WEST SUSSEX COUNTY COUNCIL CONSULTATION

TO:	Arun District Council - FAO: Harry Chalk
FROM:	WSCC – Highways Authority
DATE:	28 May 2025
LOCATION:	Newbarn Garage 65-67 Aldwick Road Bognor Regis PO21 2NW
SUBJECT:	BR/65/25/PL Change of use of existing car showroom to a self-storage unit, including the change of use of an attached ground-floor retail unit to associated office space. Extension and replacement of the existing showroom warehouse building to incorporate a first-floor and conversion of existing rear single storey extension, of the main warehouse building, to additional office space. This application is in CIL Zone 4 (Zero Rated) as other development.
RECOMMENDATION:	No Objection

Dwg No. **24004A-P-013**

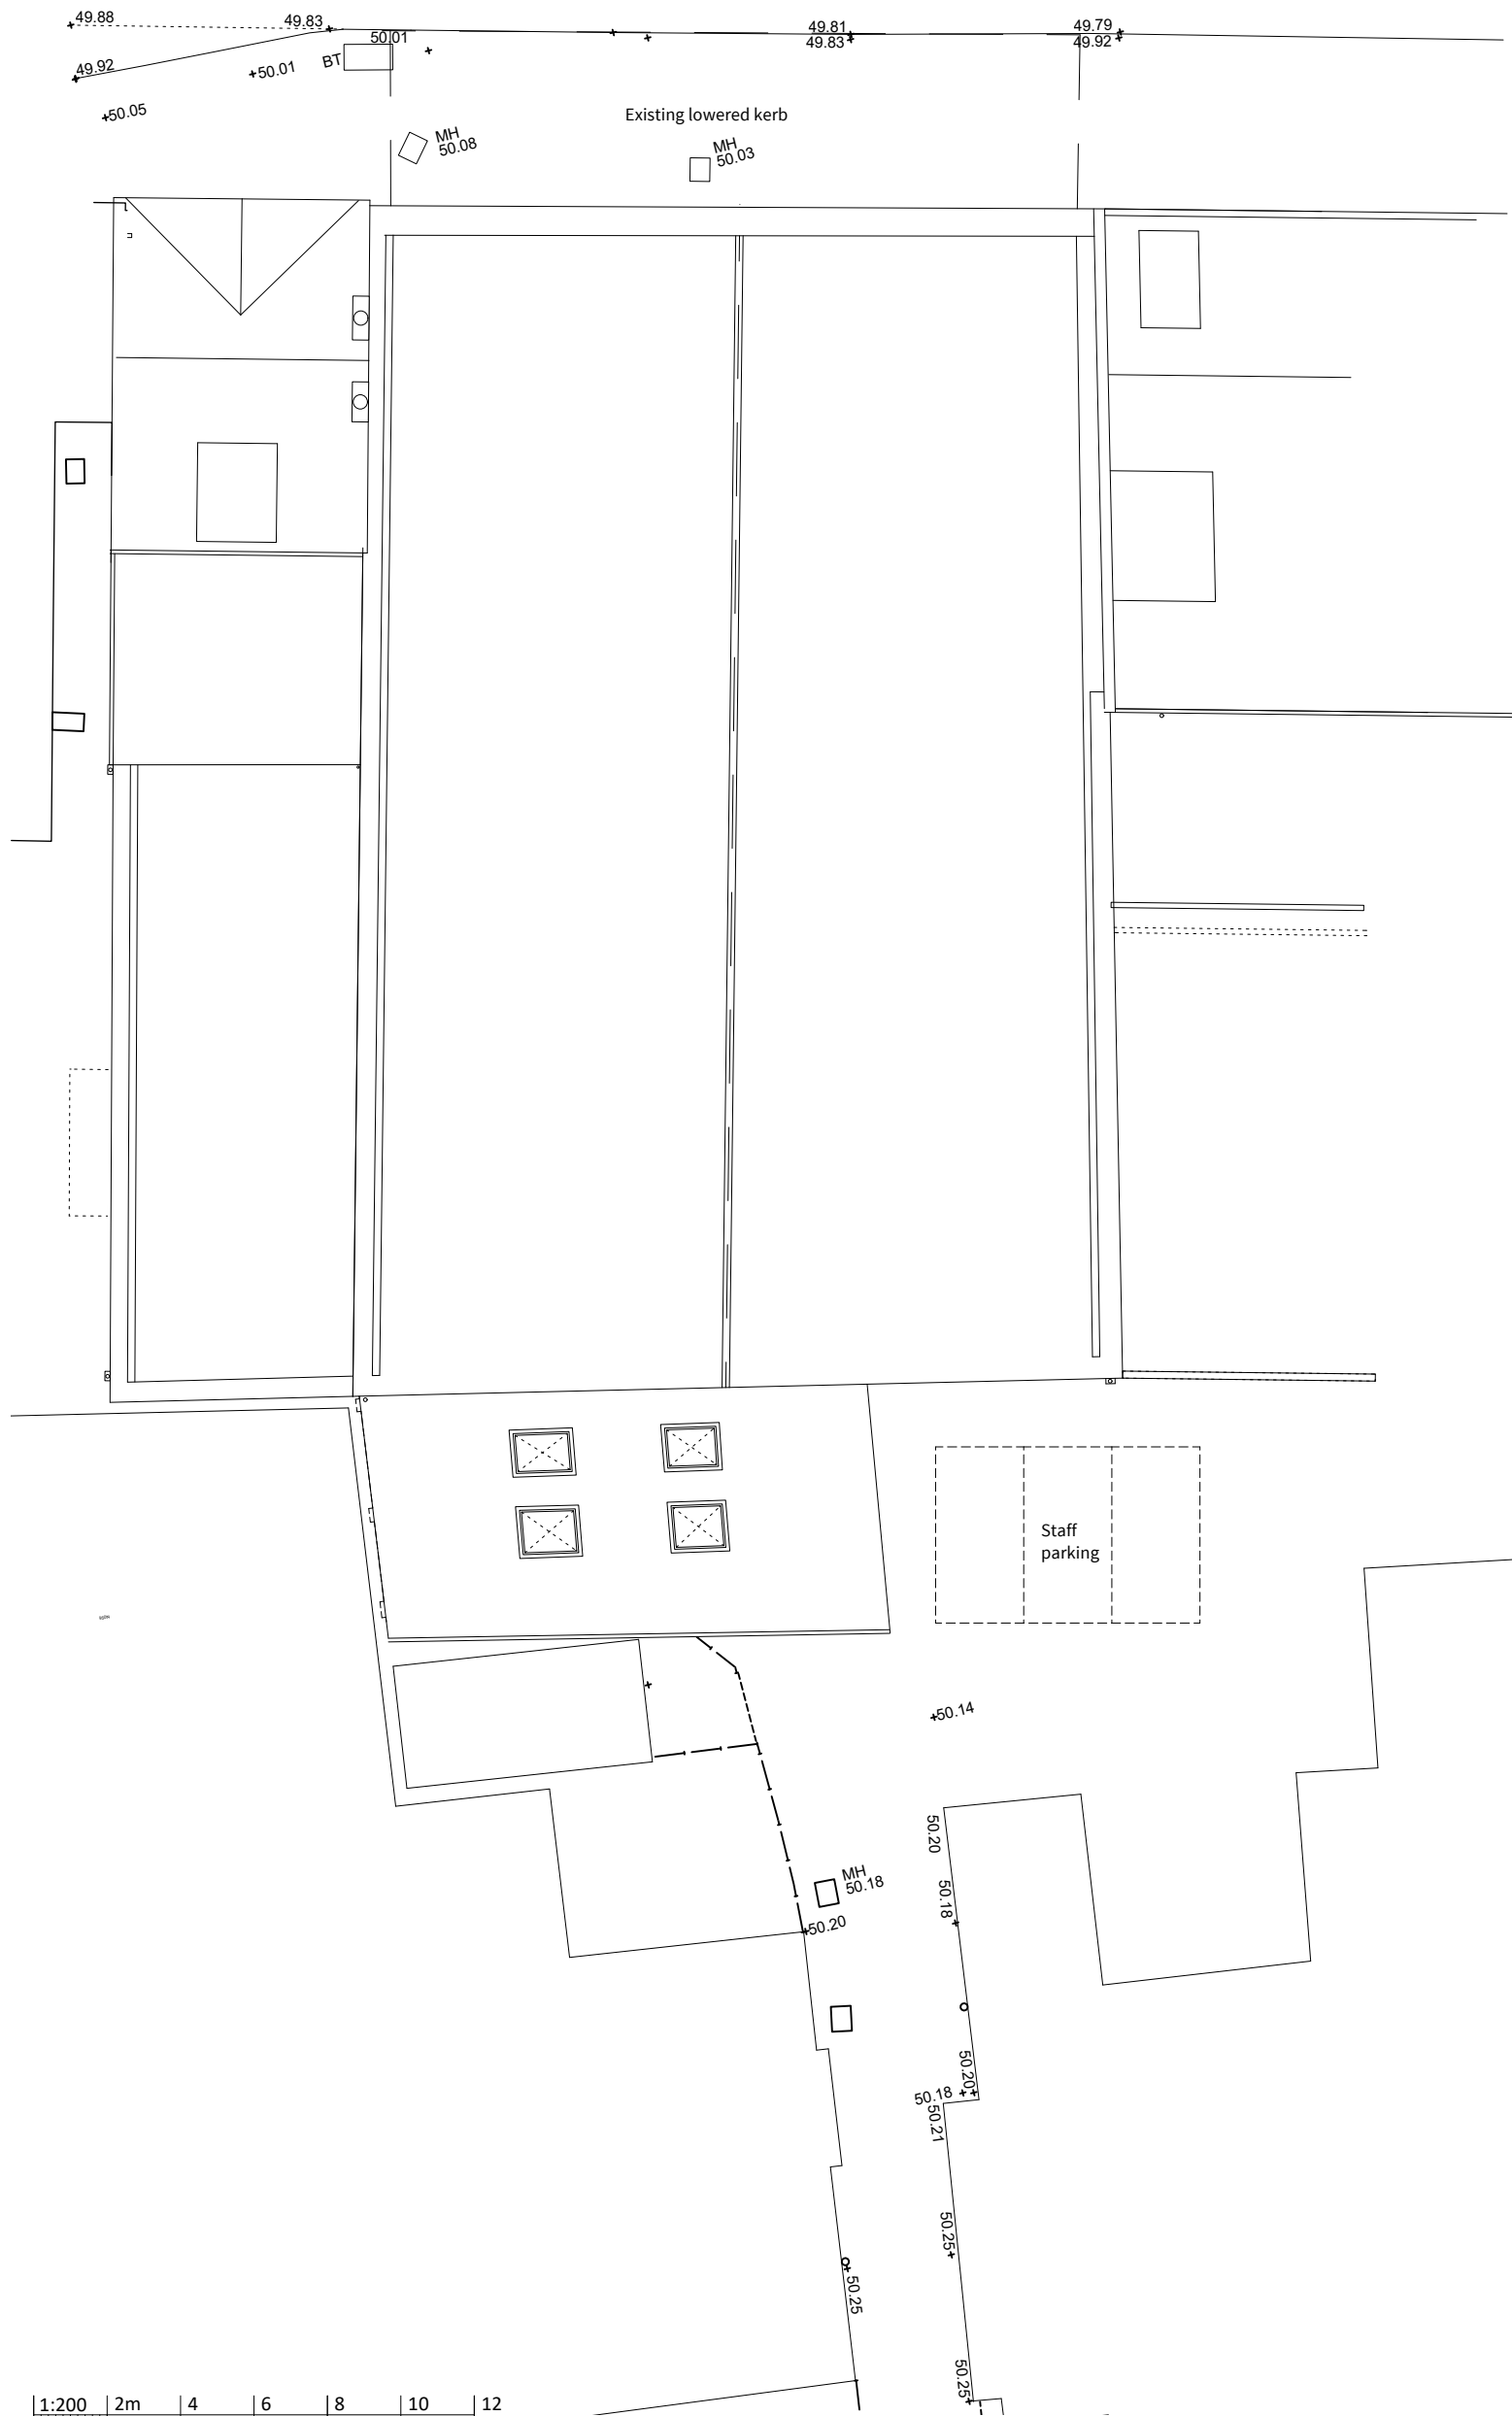
A total 9 x car spaces and 3 x cycle spaces proposed. Whilst car parking is short of demand by 4 x spaces the LHA are mindful of the accessible location and type of storage facility proposed, balanced

against estimated trip generation, the car parking provision is deemed acceptable. LHA note that bicycle storage facility actually shows provision for 6 x cycles, this should be secured by condition.

The 6 x spaces within the building show sufficient space to manoeuvre and exit to the public highway in forward gear. It is presumed that customers will be aware of limited space on site and inability to access with longer/trailer vehicles though the LPA may wish to query this with the applicant.

No part of the development shall be first occupied until the car parking has been constructed in accordance with the approved site plan. These spaces shall thereafter be retained at all times for their designated purpose.

No part of the development shall be first occupied until covered and secure cycle parking spaces have been provided in accordance with the approved plans.
